# OXFORDSHIRE COUNTY COUNCIL'S RESPONSE TO CONSULTATION ON THE FOLLOWING DEVELOPMENT PROPOSAL

**Application no:** 23/02338/OUT

**Proposal:** Erection of 15 detached and semi-detached single and two-storey dwellings (including affordable housing) together with access, parking, amenity space and landscaping - re-submission of 22/03049/OUT

**Location:** Land West Of Oxford Close And North Of Corner Farm, Station Road, Kirtlington

TITLE:  
**Proposed Site Access -  
Vertical Visibility Splays**

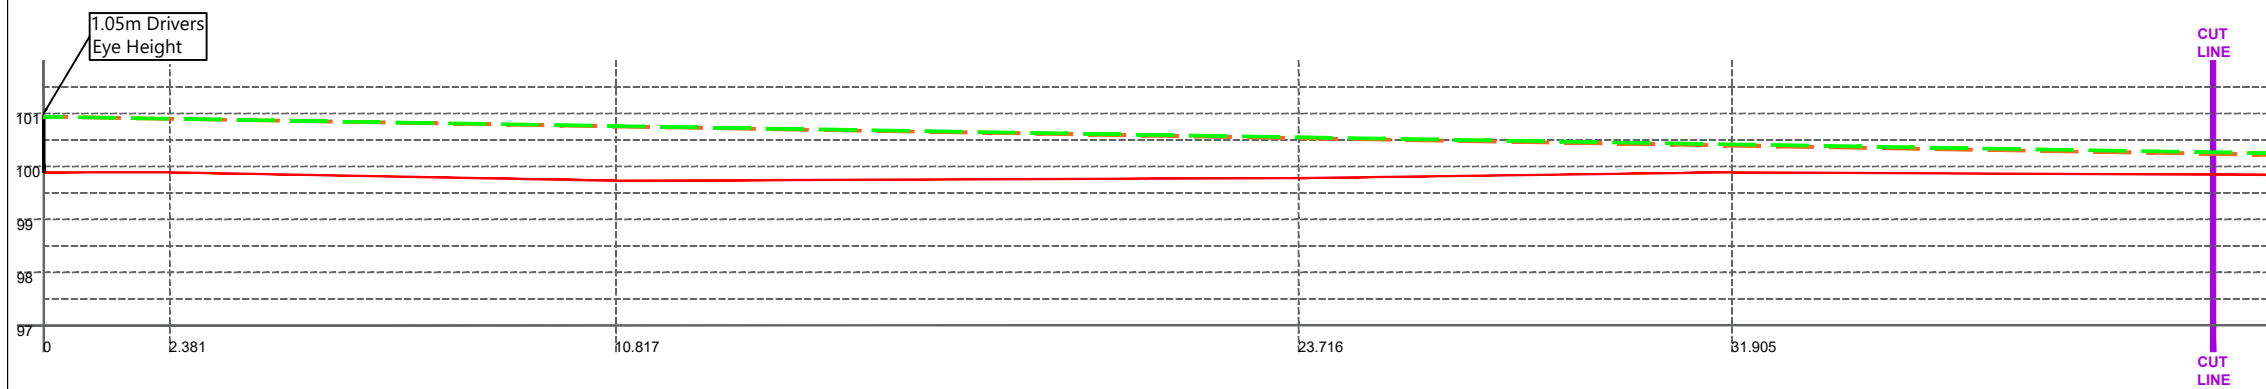
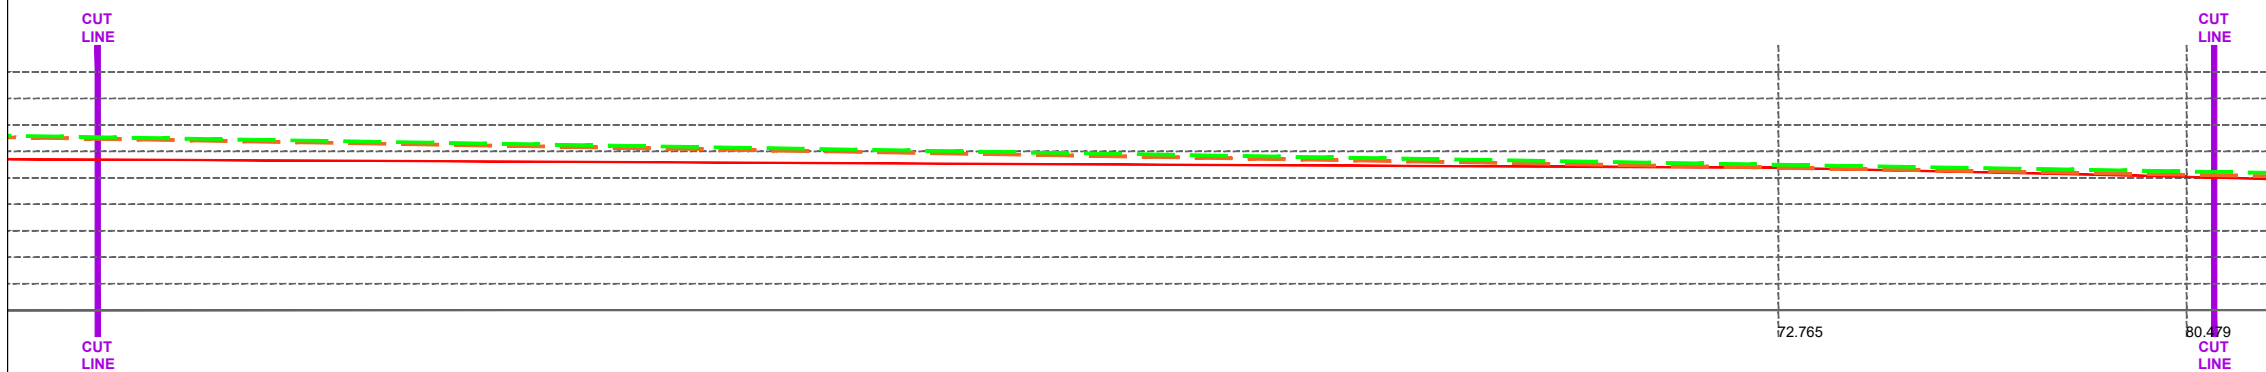
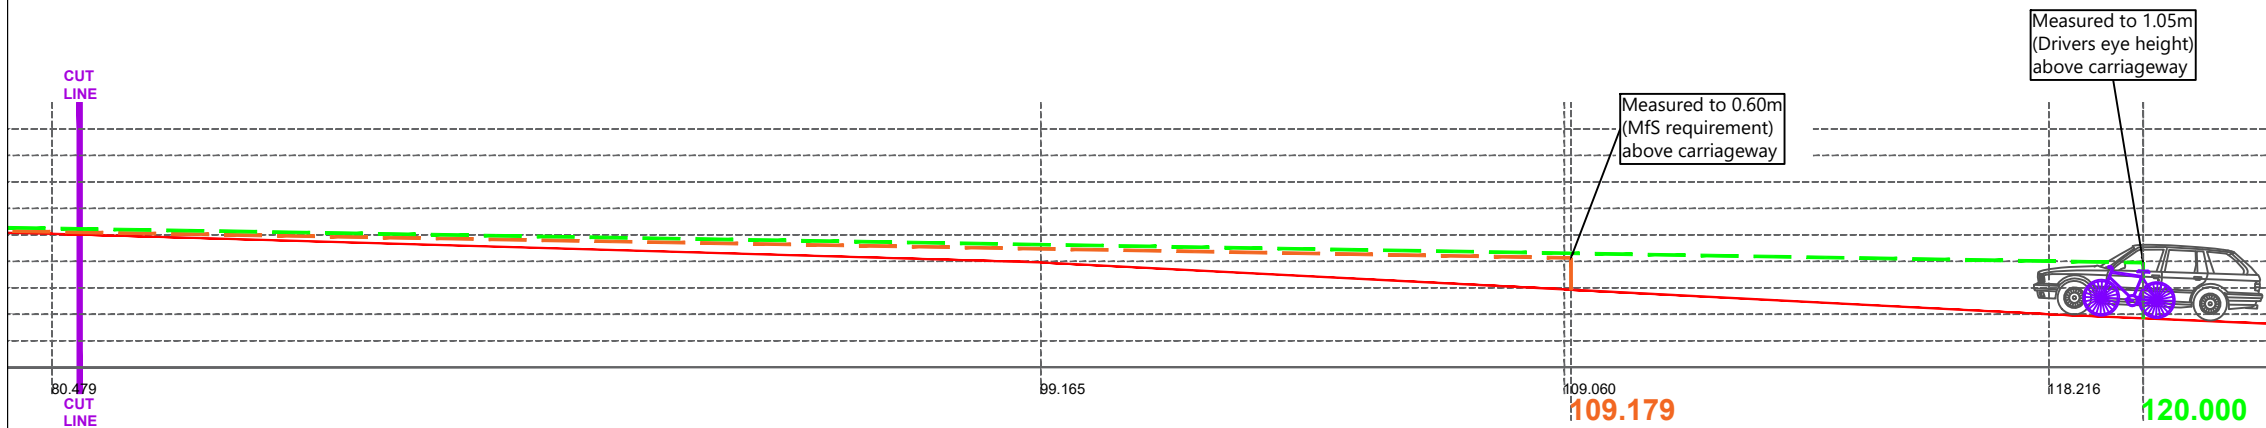
Access is proposed onto Lince Lane (A4095) immediately north of the existing 20mph speed limit sign, on the outside of a curve. The speed limit to the south is 50mph. The transport statement says there is a visibility splay of 2.4m x 120m to the south, with the sight line crossing the opposite verge on the inside of the curve. However, having revisited the site, we find this is not achievable, due to the gradient and vegetation. Visibility measured along the edge of the northbound carriageway is between 90 and 100m. Therefore, the drawing is misleading in our opinion, and this is a **reason for objection**.

The drawing should be resubmitted showing the achievable visibility splays, together with the speed survey data and a Stage 1 Road Safety Audit (RSA1) in accordance with GG119 (5.46.1) A Designers Response should accompany the RSA1 with the Overseeing Organisation agreeing and signing off the RSA.

Drawing Title:  
**PROPOSED SITE PLAN:  
Means of Access  
For Consideration  
only**

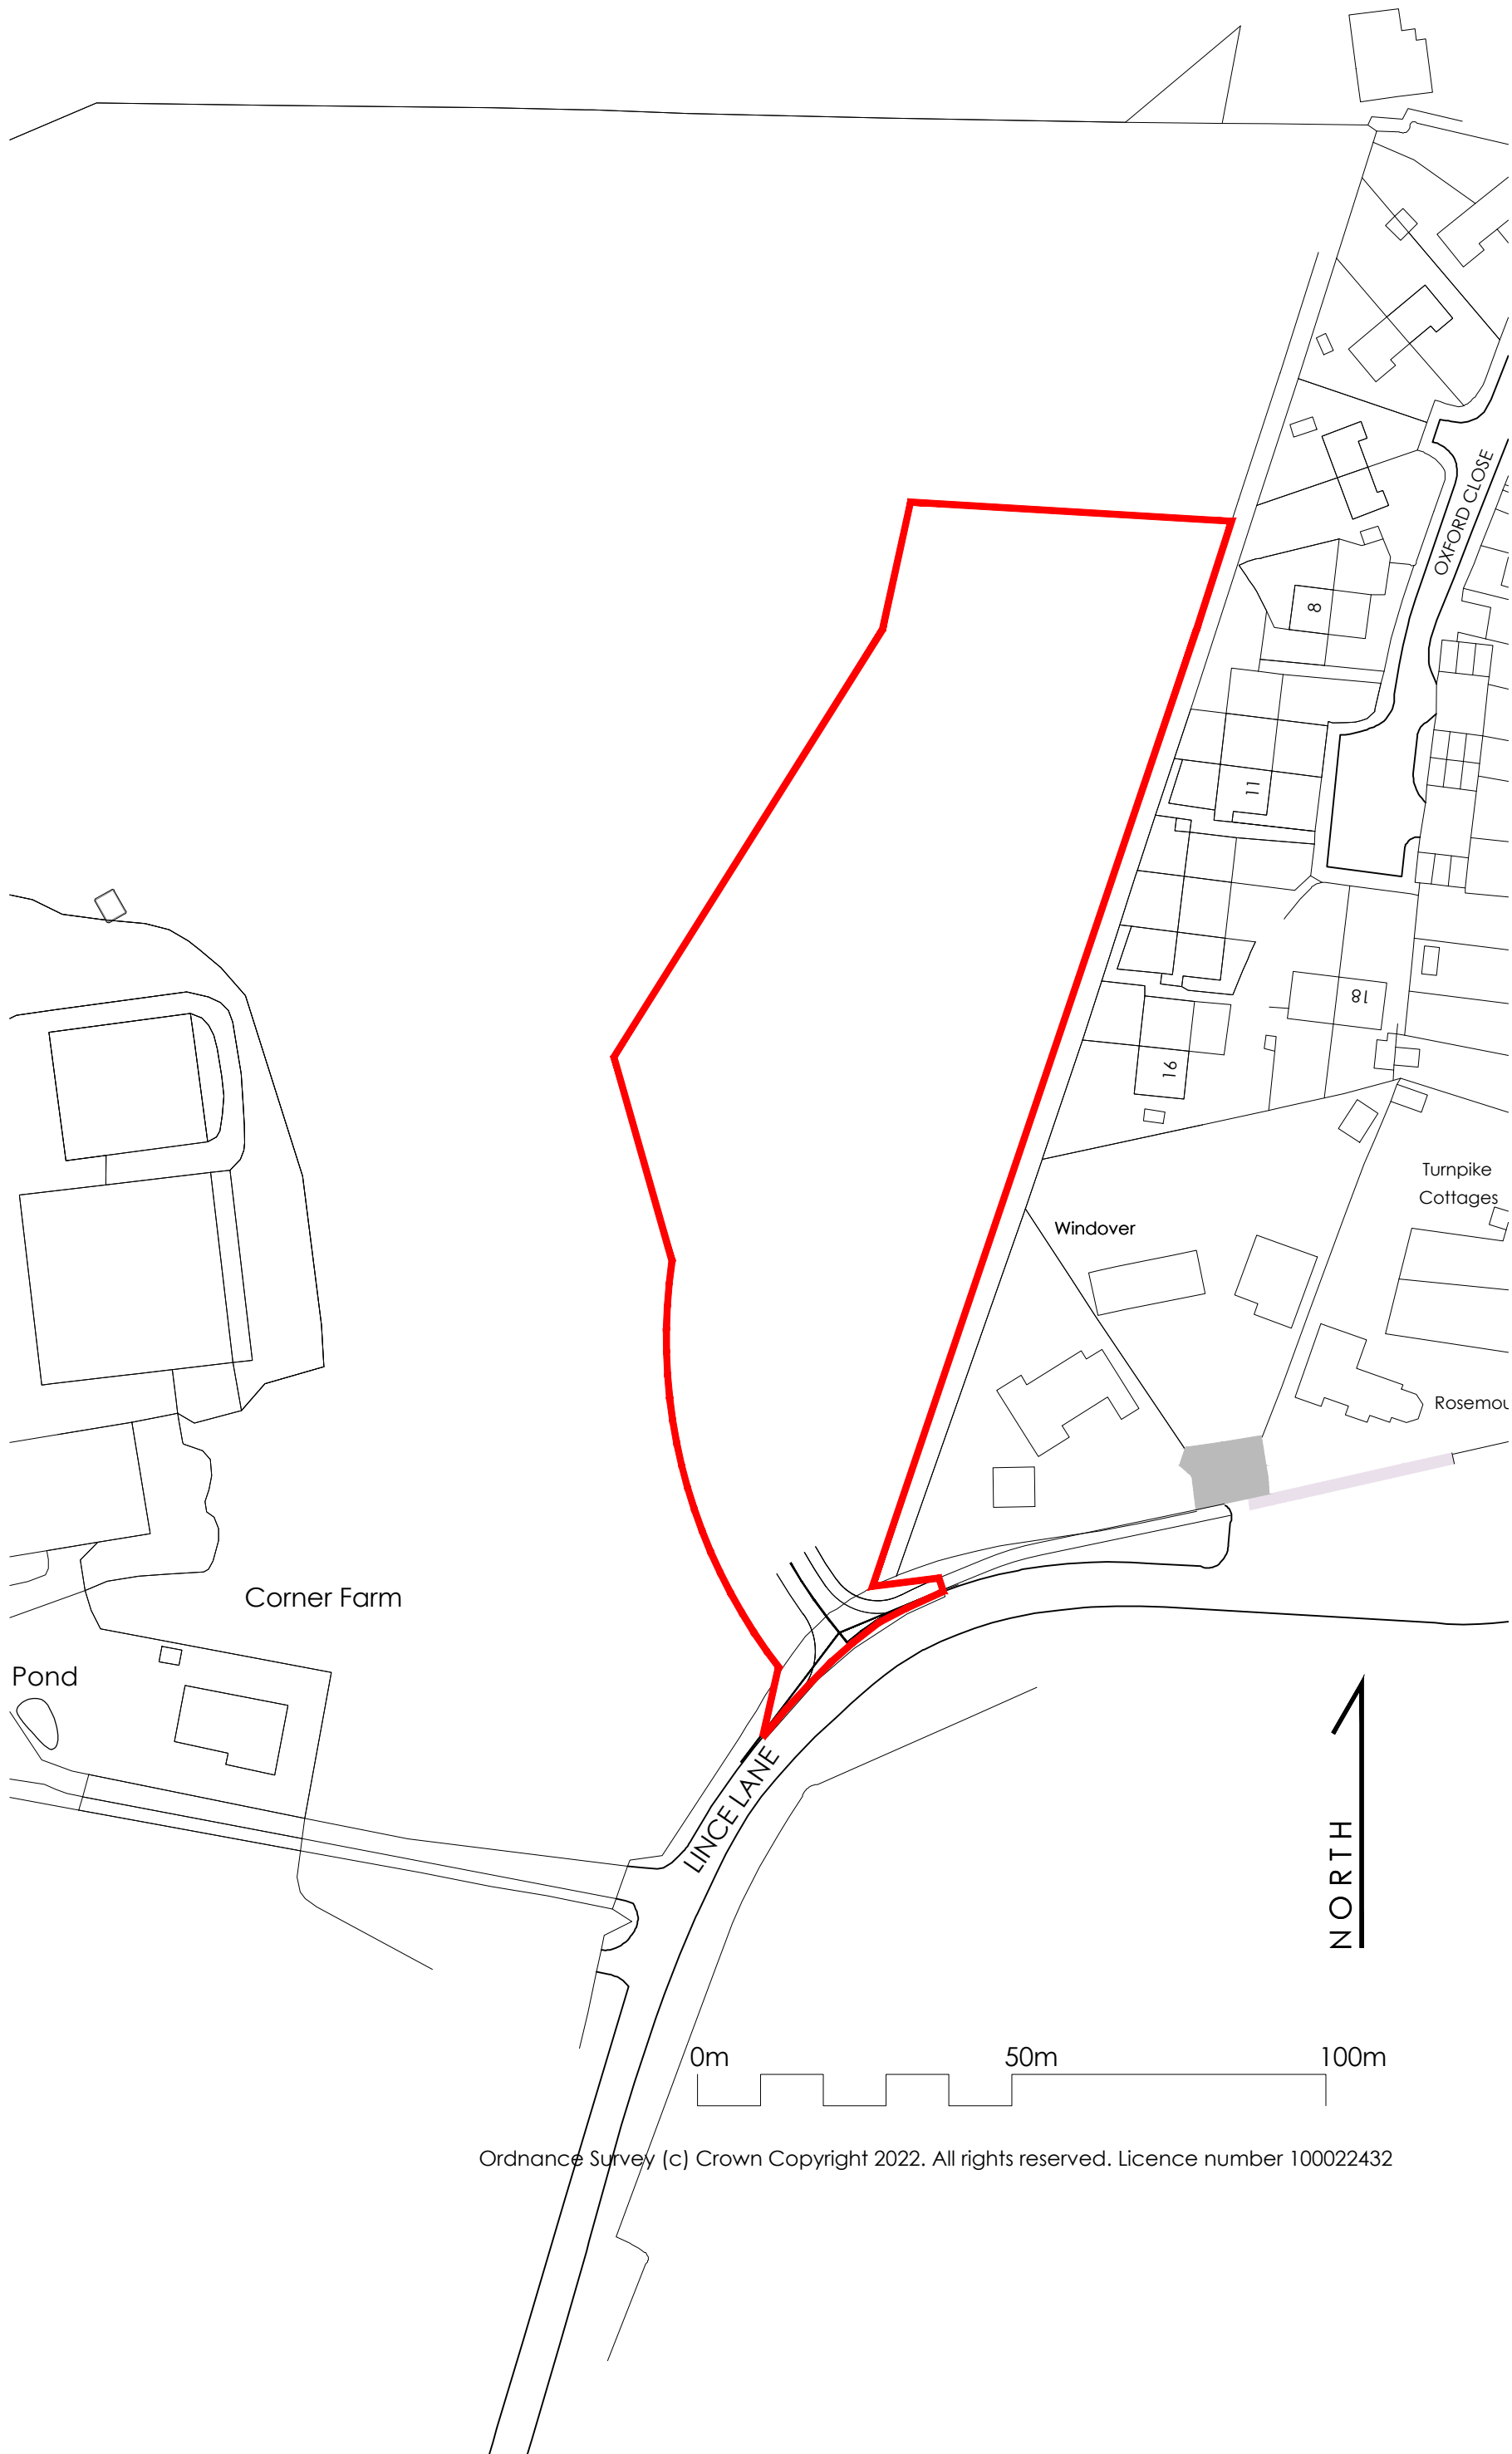
The application proposes to provide a 2m footpath into the site, and to extend this along the verge, linking to the existing footpath towards the village. The existing footpath is in need of improvement further towards the village, opposite the junction with Bletchingdon road, where there is a small unsurfaced gap. This should be improved as part of the S278 works, to provide a continuous walking route.
